EN010085 - Application by Cleve Hill Solar Park Ltd for an Order Granting Development Consent for the Cleve Hill Solar Park

RE: Advice Following the Issue of Decision to Accept the Application for Examination

Table 1 - Applicant's Response to Inspectorate's Observations

Sheet 1 of 4

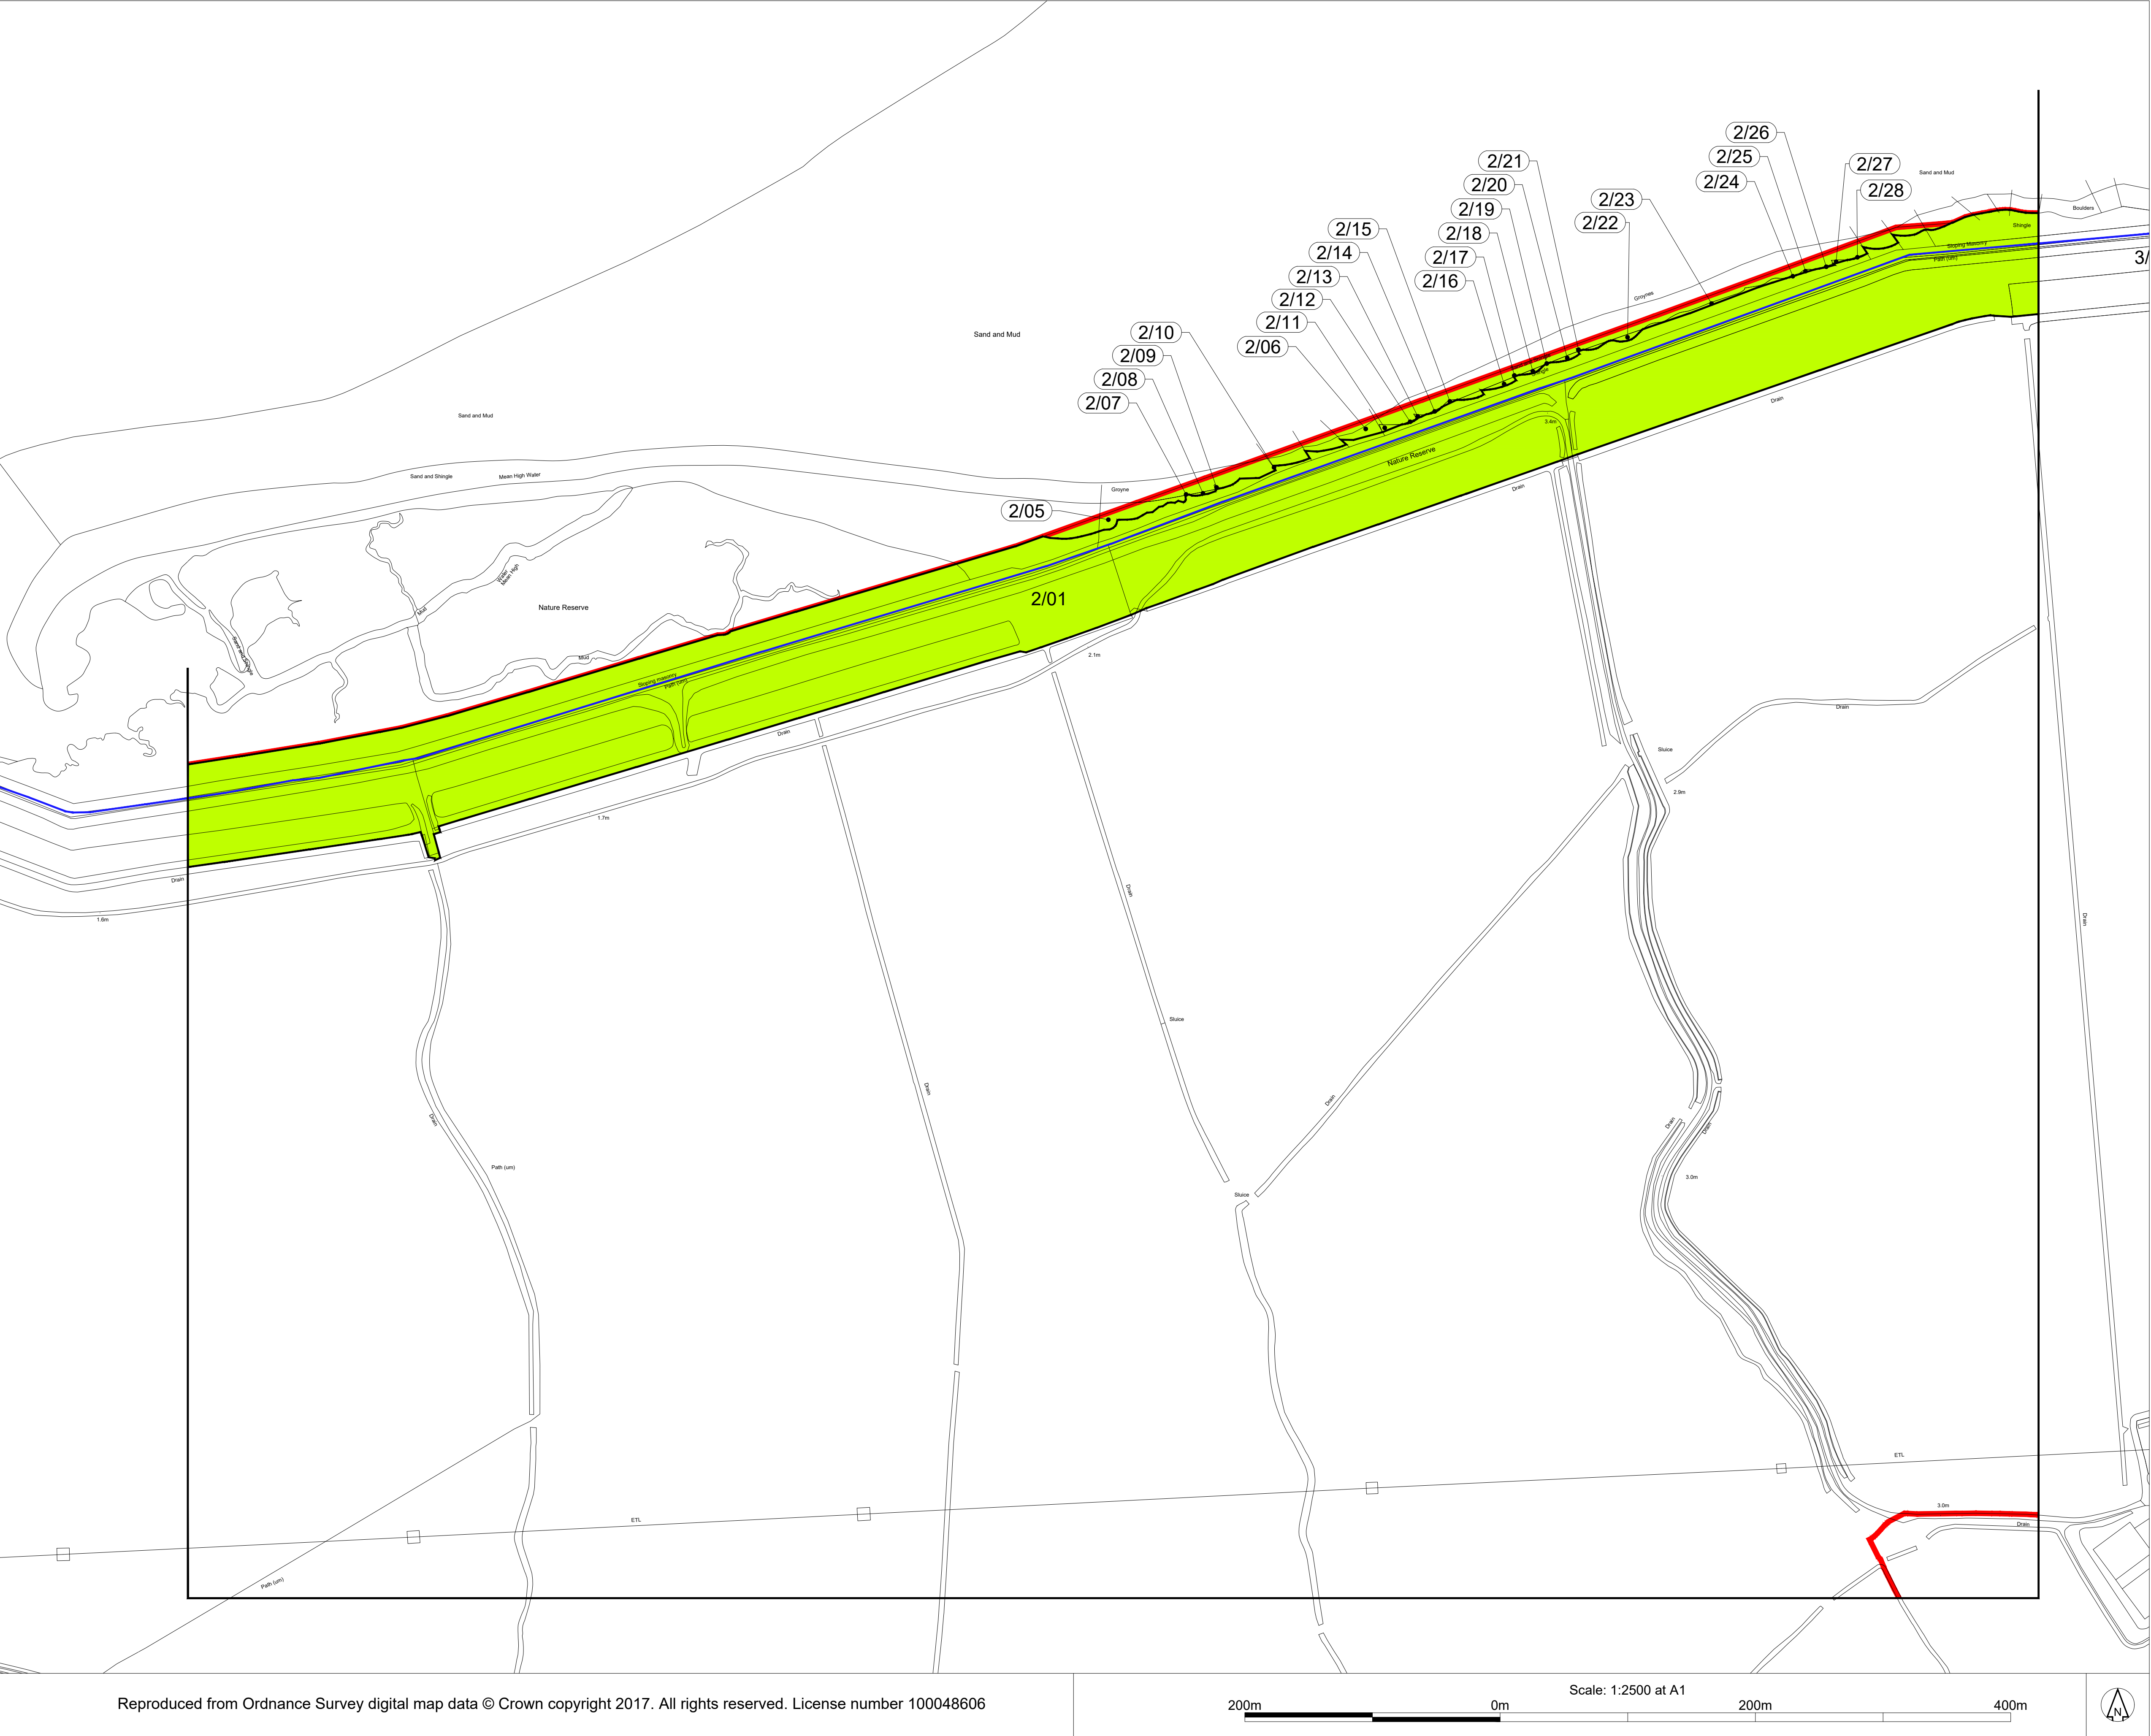
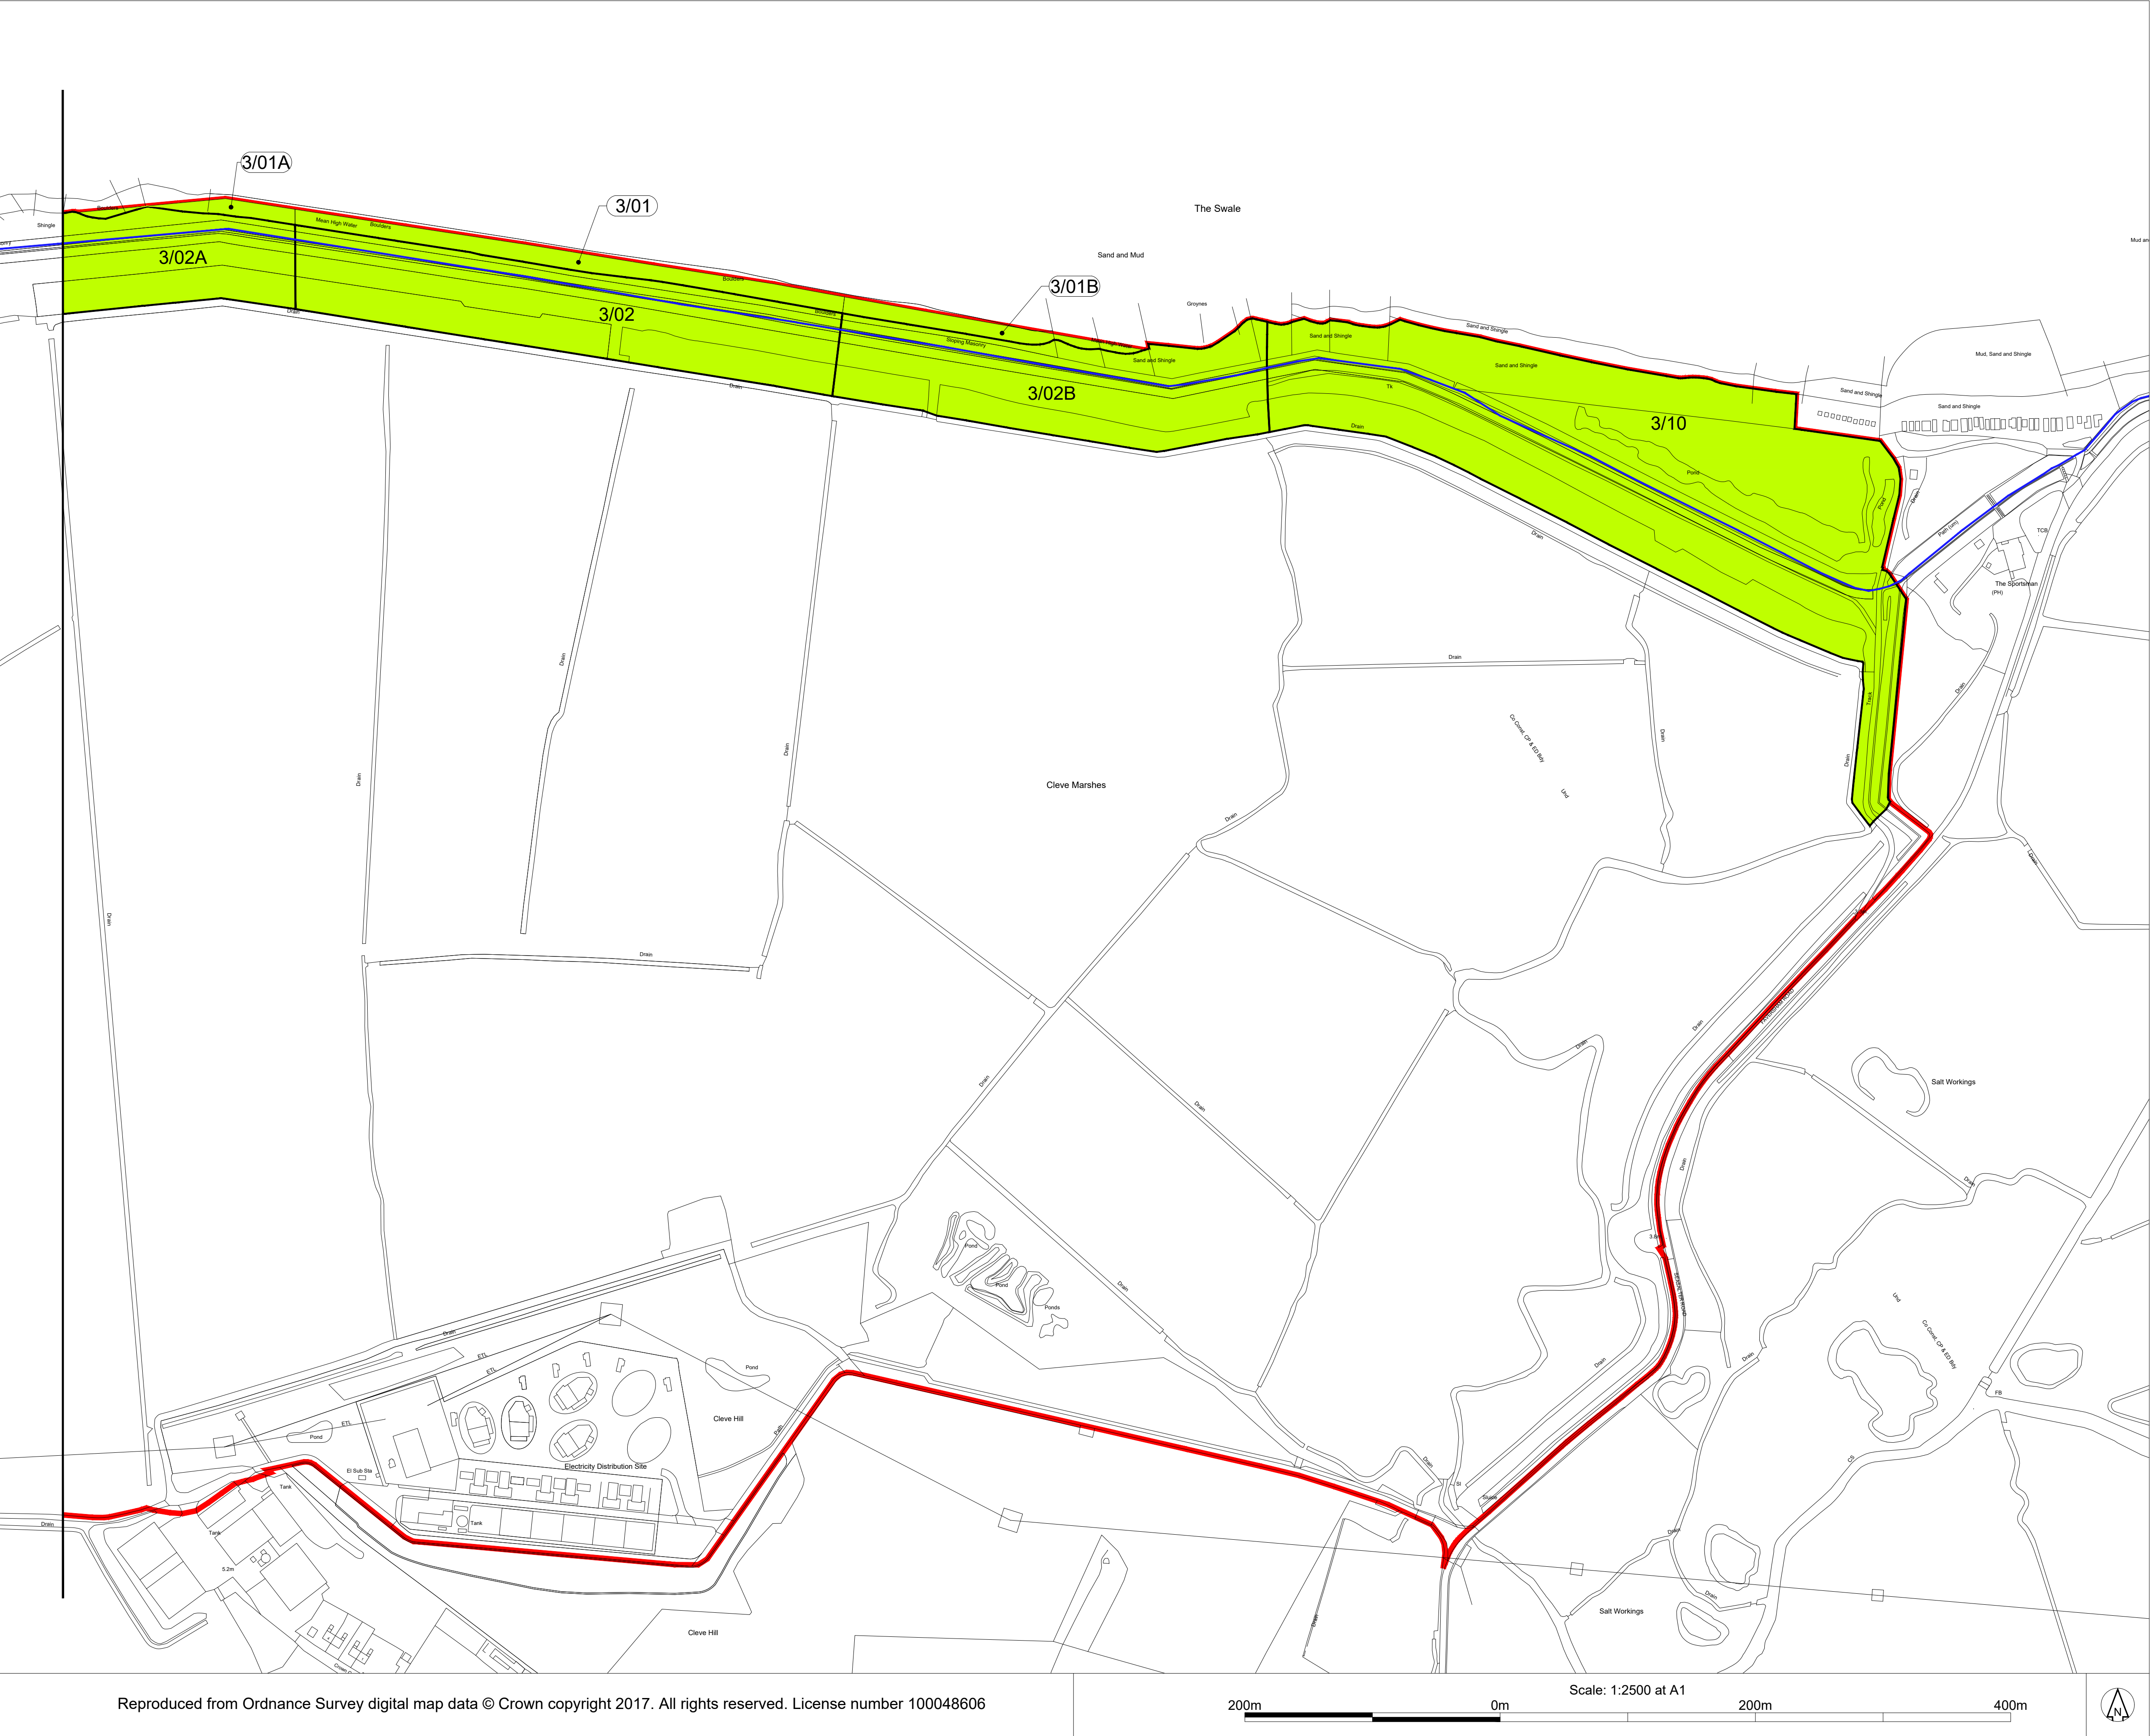
<p>Special Category Land Plans:</p> <ul style="list-style-type: none"> • Some plots (1/08, 2/02, 3/02A, 3/02B, 3/10) are subdivided (only a given area of a plot is used for 'open space'). • Plot 1/08 states in the Book of Reference – part 5 that only a part of the plot is required, all other plots where only part of the plot is depicted on the plans as needed for 'open space' just state the plot number. Plots 4/01 - 4/03 in the Book of Reference are not separately identified on the plans 	<p>This is correct, the Open Space Land Plan details the part of the plots that are considered to be open space.</p> <p>Part 5 of the Book of Reference has been updated to make it clear that only part of these plots is considered to be open space.</p> <p>Plots 4/01 and 4/03 were missing on the submitted plans in error. These plots are shown on Revision B of the enclosed Open Space Land Plan.</p>
